Application number: 2026/90909	
What is the application for?:	Erection of single storey front and two storey rear extensions
Address of the site or building:	7, Milford Grove, Birkenshaw, BD19 4BB
Postcode:	BD19 4BB

Type of comment: An objection	
Do you wish your comments to be published on the website anonymously?	No
I wish to formally object to planning application 2026/62/90909/E for a two-storey extension at 7, Milford Grove, Birkenshaw, BD19 4BB. I live in the neighbouring property (9 Milford Grove) and my objections are set out below: 1. Loss of Light and Overshadowing The proposed scale, height, and siting of the extension would result in a loss of daylight and sunlight to my property, shadowing the rear garden and conservatory during the morning period. The extension has not been designed with any consideration to the impact on my property. This is clear from the plans which fail to show the location of my conservatory adjacent to the extension. Without this detail, the Council cannot properly consider the impacts of the development. 2. Overbearing Impact The extension would appear dominant and overbearing due to its massing and scale. Currently, all the neighbouring prope

DRAWING TITLE:
PROPOSED DRAWINGS

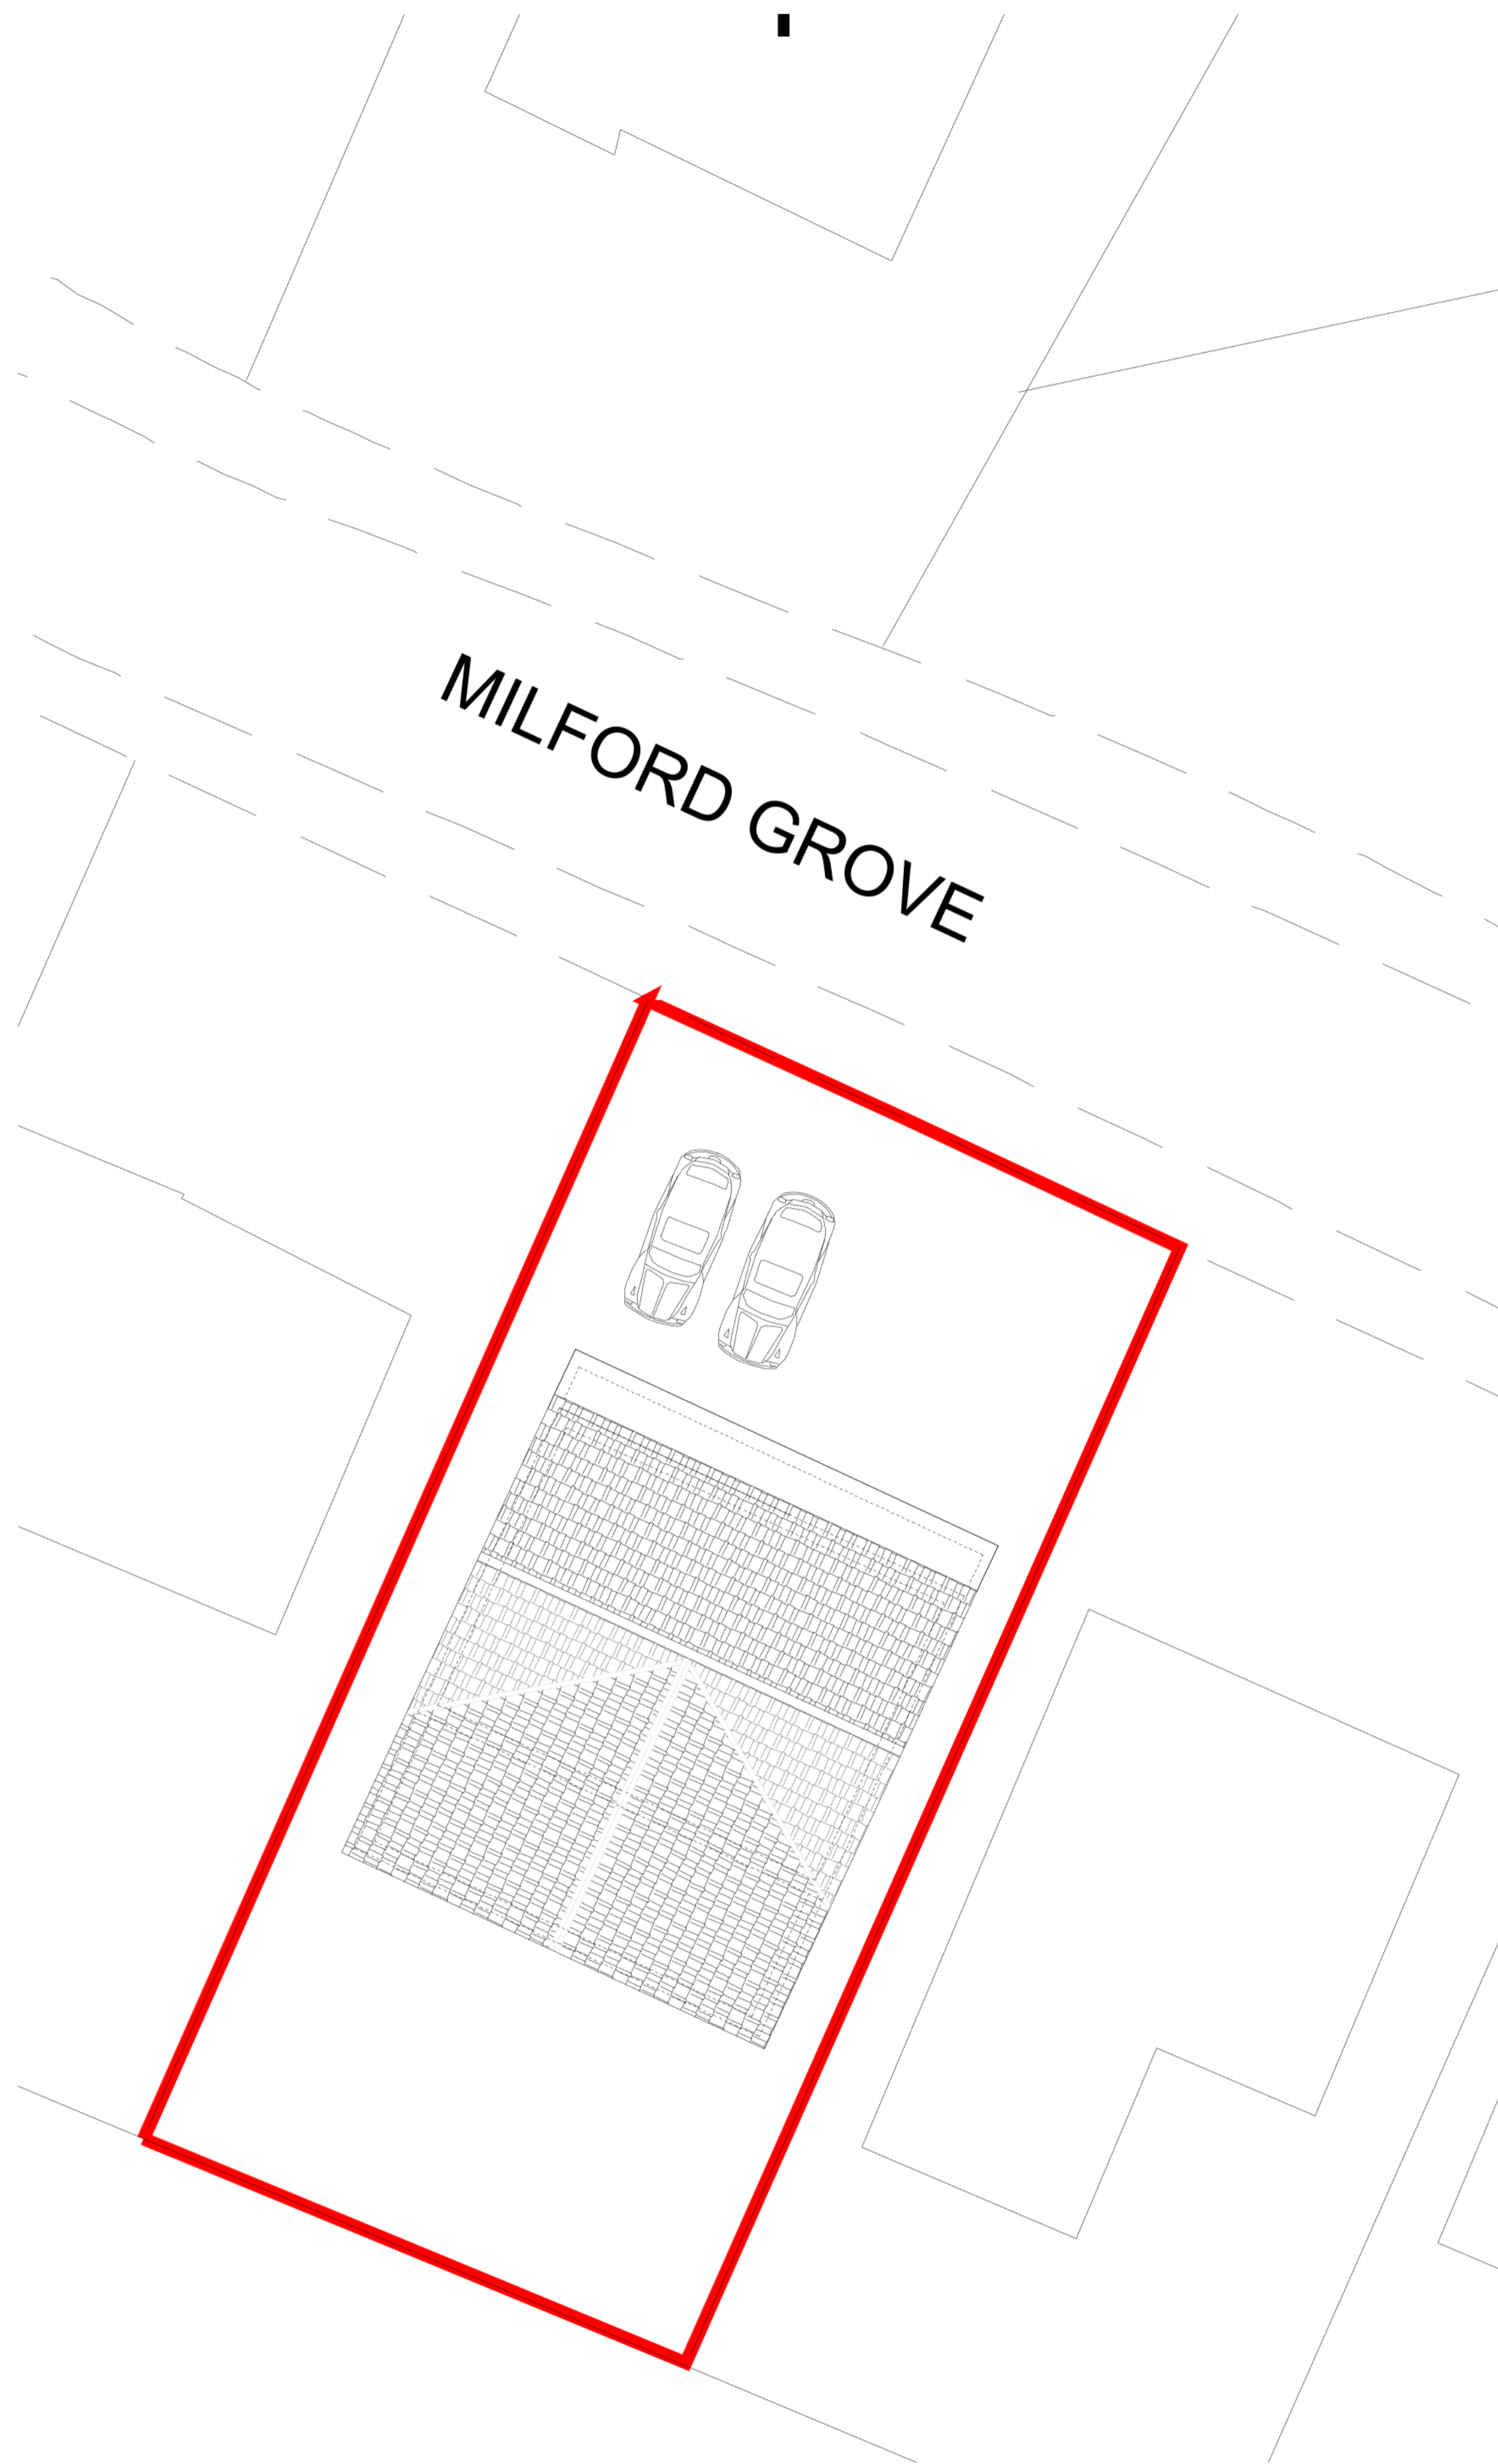
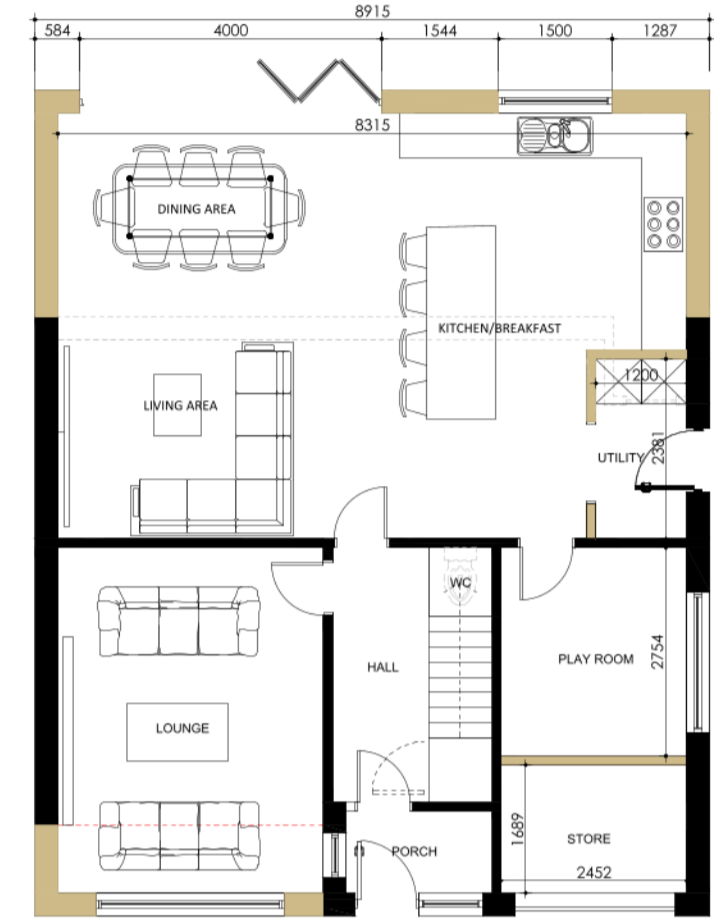
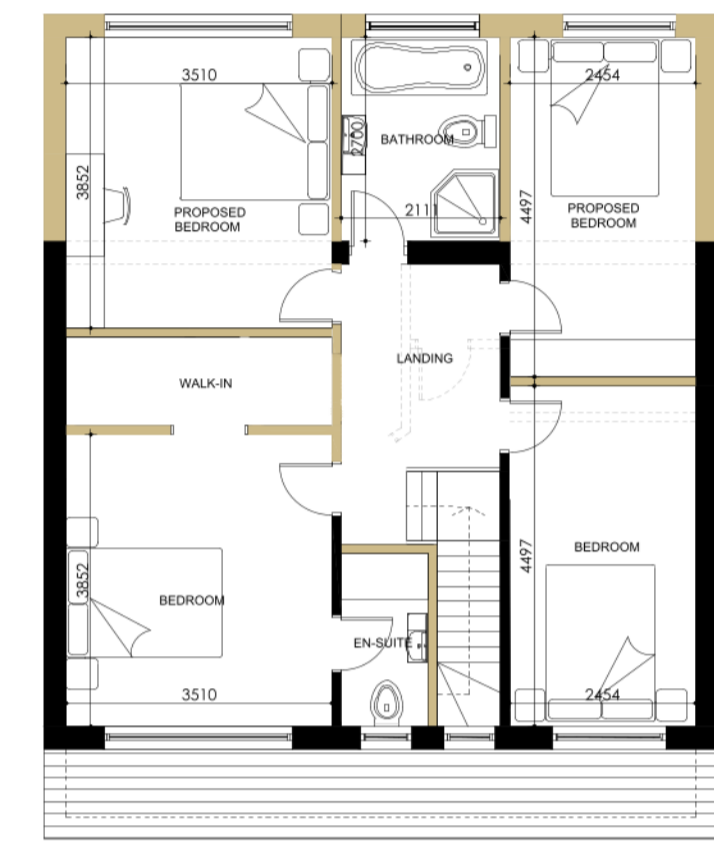
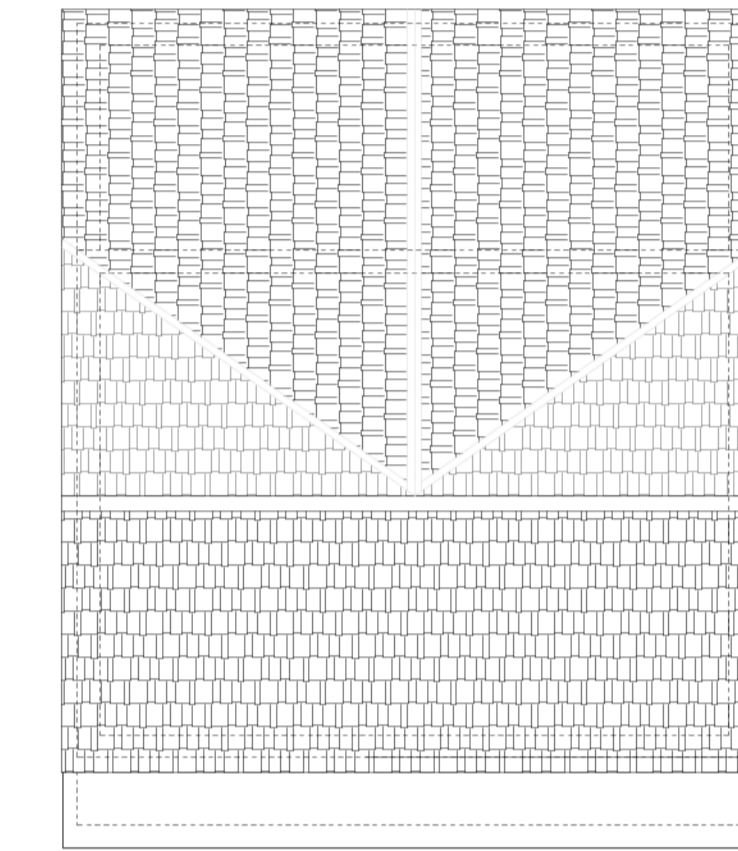
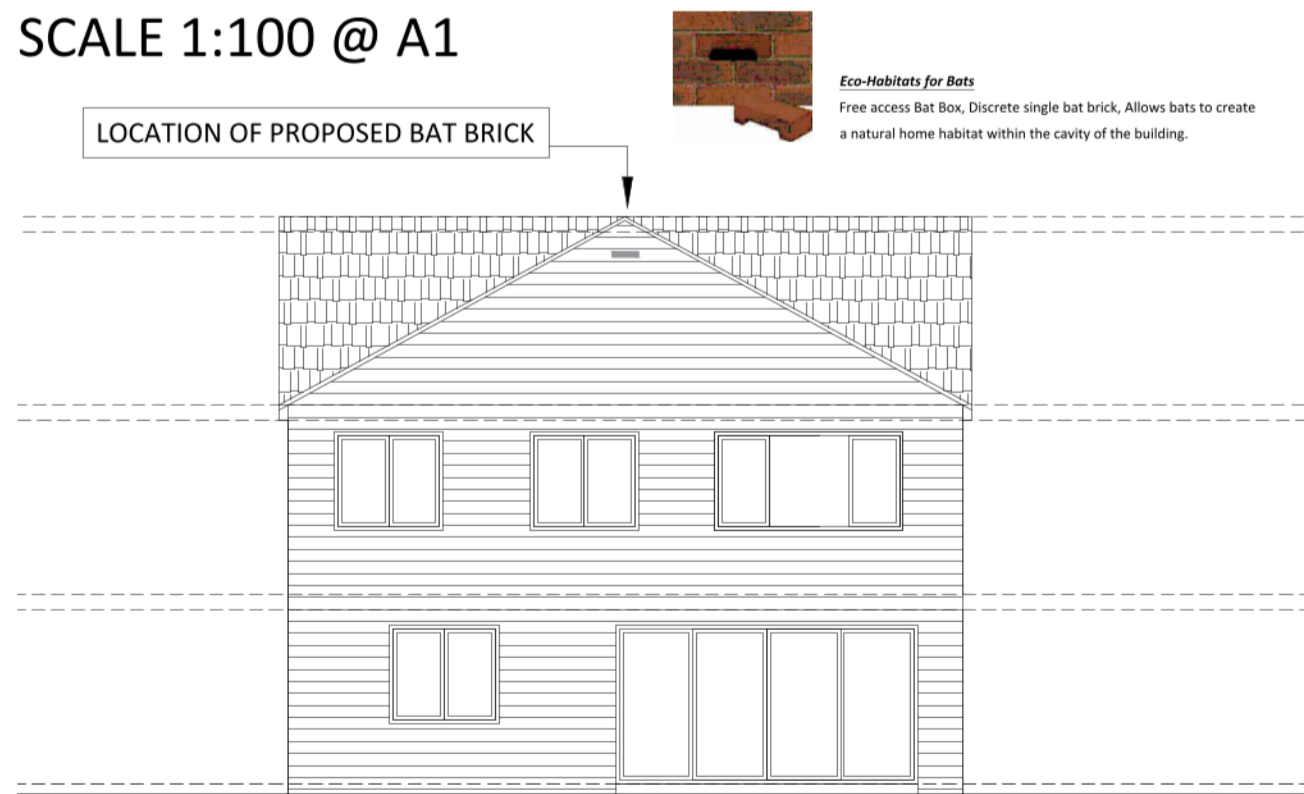
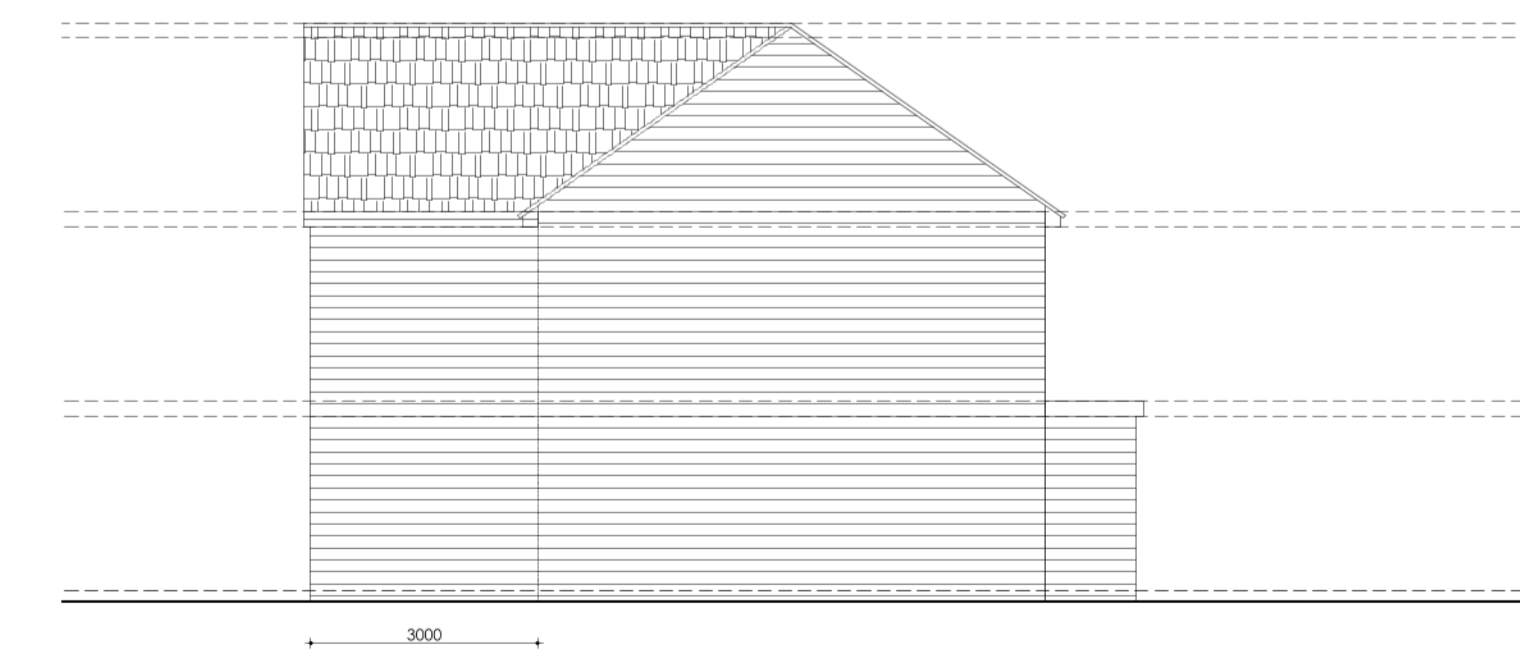
5. Compliance with the Kirklees House Extensions Supplementary Planning Document
The plans show no annotation of measurements for the height of the extension or distance from the boundary lines. However, I would make the following comments. The SPD states that rear extensions should preserve a back garden of reasonable size and follows a general principle that at least half of the garden is retained. It is difficult to calculate from the plans the exact amount of rear garden area left after the development however, for the plot size, the scale of the proposed extension appears excessive.

The SPD states that an extension should not exceed the height of the eaves by more than 3 metres and should be separated from the property boundary by at least 1.5 metres. It is not clear whether the proposal is compliant with this guidance. Even if it can be confirmed that the proposal is compliant, the above objection are a result of the height and massing of the proposal which is not policy compliant as a result of the impacts on my property.
